Current Zoning: ML-2 (manufacturing and logistics, 2)
Proposed Zoning: TOD-NC(CD) (transit oriented development, neighborhood center, conditional)

Approximately 4.54 acres located in the southwest quadrant of the intersection of Wilkinson Boulevard and Remount Road, north of Parker Drive.

The petition proposes to allow all uses in the TOD-NC district on lots that are currently vacant. The conditions of the plan reserve right-of-way for the future LYNX Silver Line.

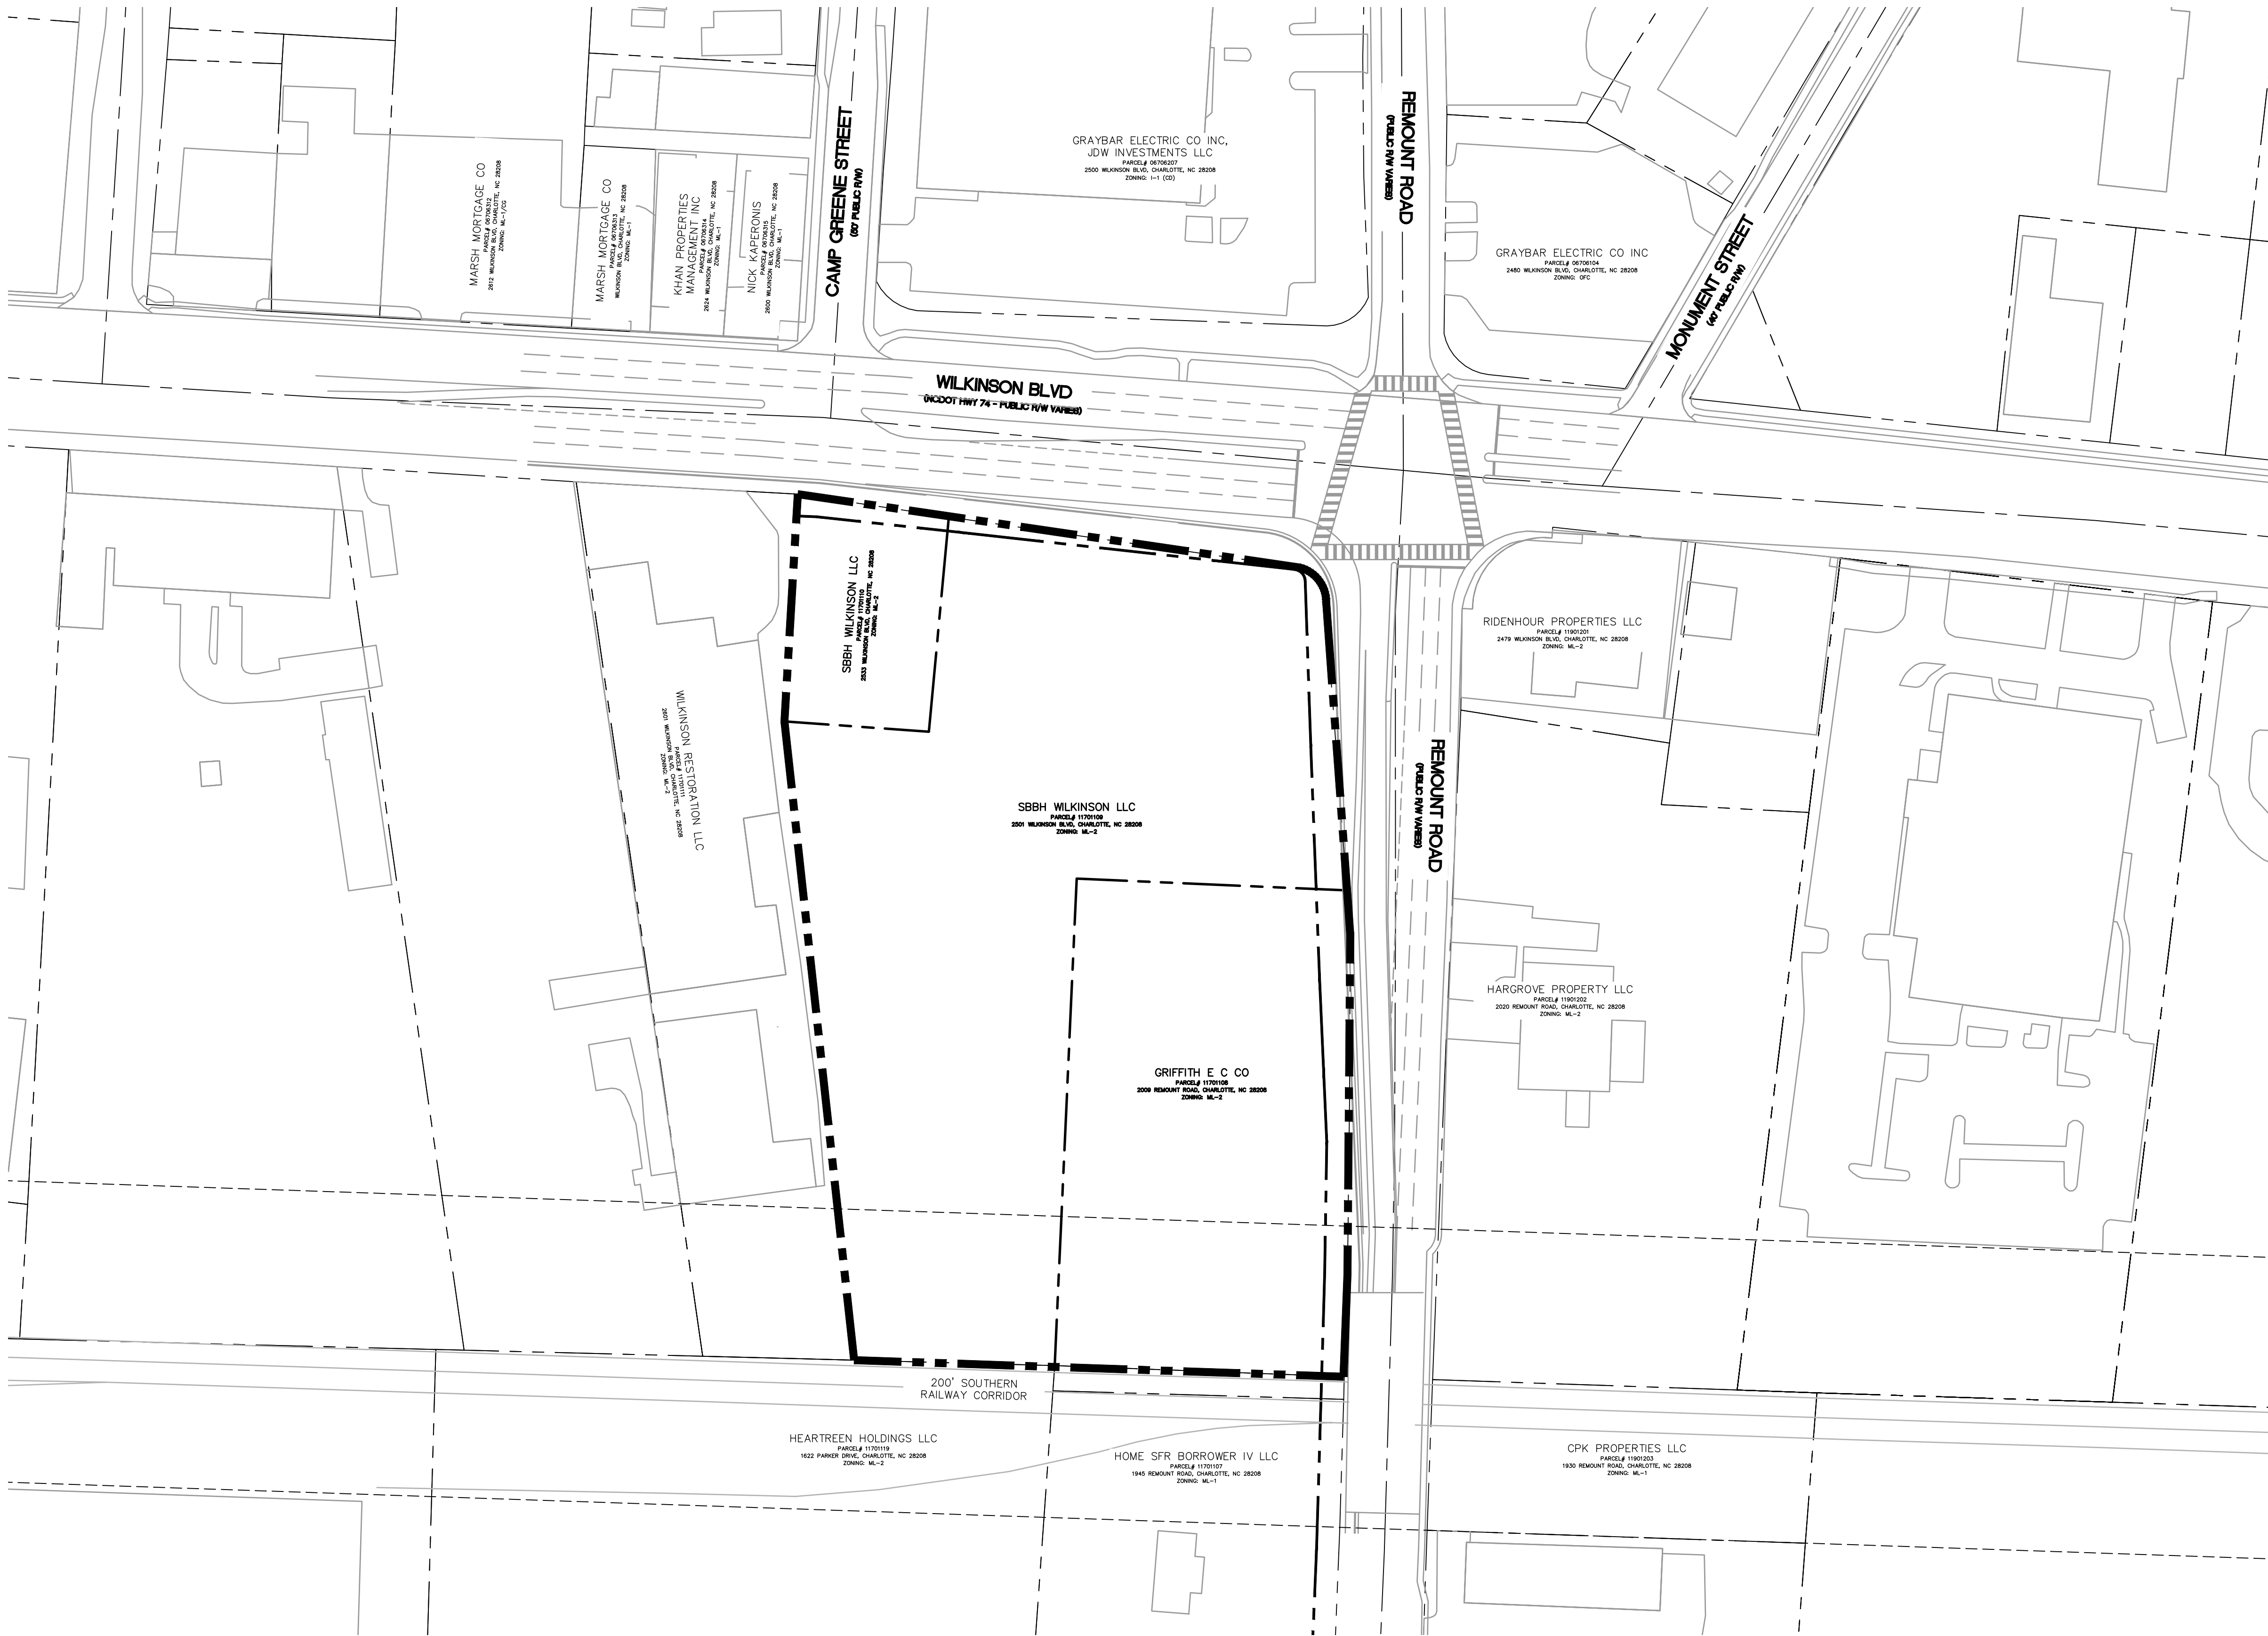
- The site is located at the intersection of Wilkinson Boulevard, a State-maintained commercial throughfare, and Remount Road, a City-maintained minor throughfare. Site plan and/or conditional note revisions are needed to commit to label and dimension the ROW on Wilkinson Boulevard and Remount Road and add conditional notes to the site plan.

1. Revise the conditional notes to include a note stating, "Petitioner will coordinate with CDOT during permitting for determination of need for TIS based on ordinance requirements and proposed land uses and density."
 2. Revise the site plan to dimension and label the right-of-way from the road centerline.
-
